From: [Downes, Scott G \(DFW\)](#)
To: [Alex Cordas](#); [Lindsey Ozbolt](#); [Dusty Pilkington](#)
Cc: [Eric Morris](#); [Nelson, Jennifer L \(DFW\)](#)
Subject: RE: LP-17-00007 Swauk Valley Ranch Updated Stream Mapping Information
Date: Monday, March 26, 2018 8:06:28 AM
Attachments: [Swauk Valley Ranch Tributary Stream.pdf](#)

Attached is a pdf of the information to update the unnamed tributary of Swauk Creek that runs west to east and near the proposed plat changes on Swauk Valley Ranch. This should help to square away the question on both stream location as well as stream type. On typing while it currently is a borderline call of between Type 2 and Type 3, it is a Type F (fish bearing) and under the new proposed CAO, the Type 2 and 3 will be going away to be replaced with Type F to make it consistent with DNR water typing maps.

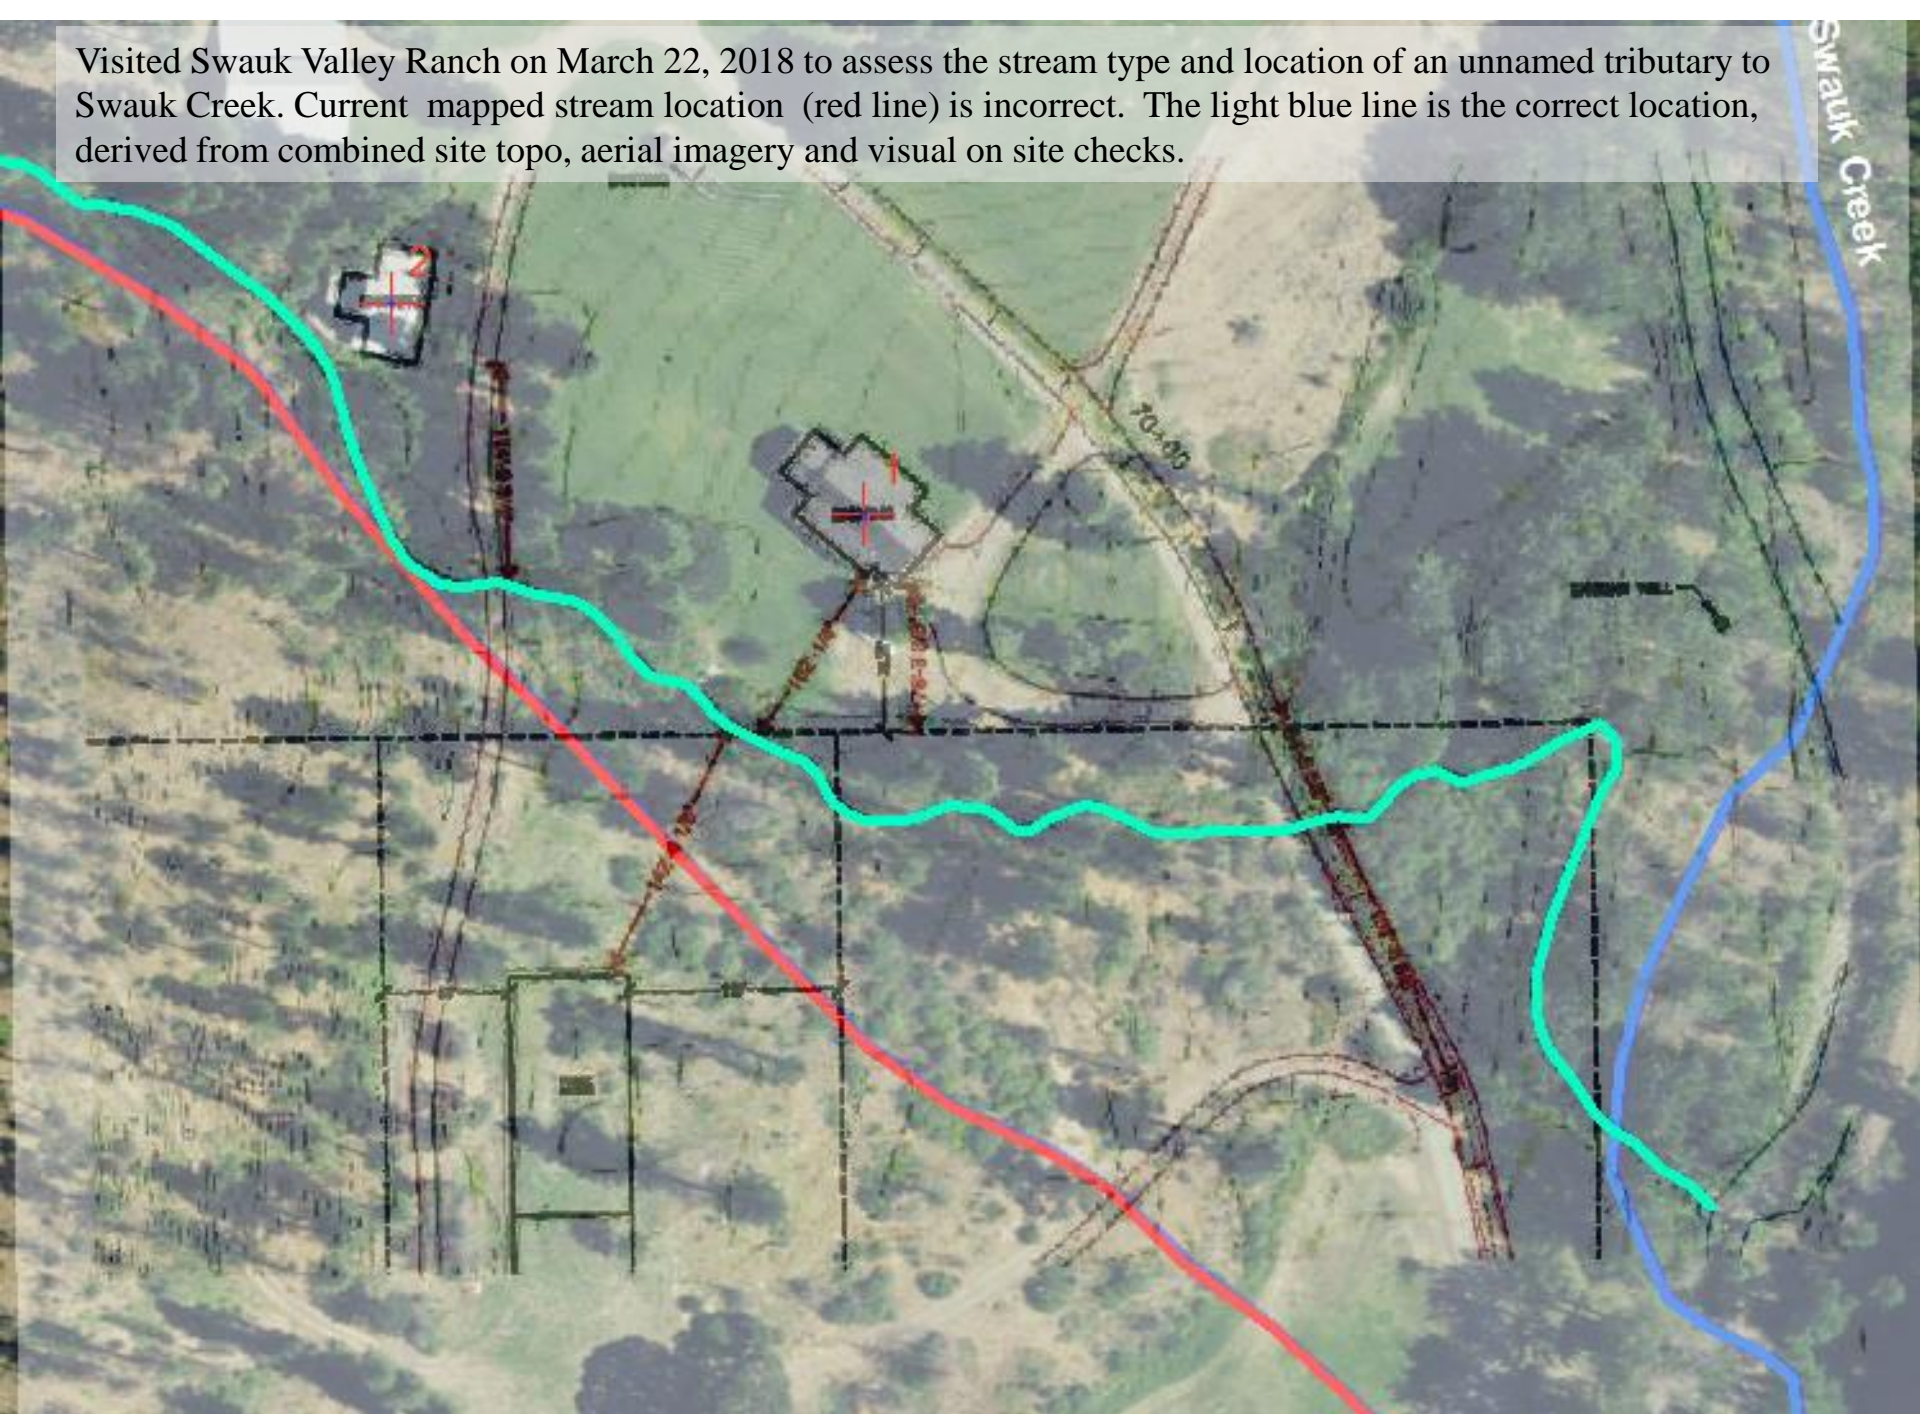
Outside of the immediate housing area,
the stream location was corrected to
Reflect the true stream location. None of
the side tributaries were checked.

Location of currently mapped stream location looking up the mapped stream. Stream is mapped across the lawn and brush, no signs of stream.

Actual location of stream and condition. It meets the physicals for a fish bearing stream and has good connection to Swauk Creek. Stream is seasonal, going dry in May according to locals, but is likely used by fish during the seasonal period. Thus it is a Type F stream, borderline between a Type 2 and 3 stream under the old labels.
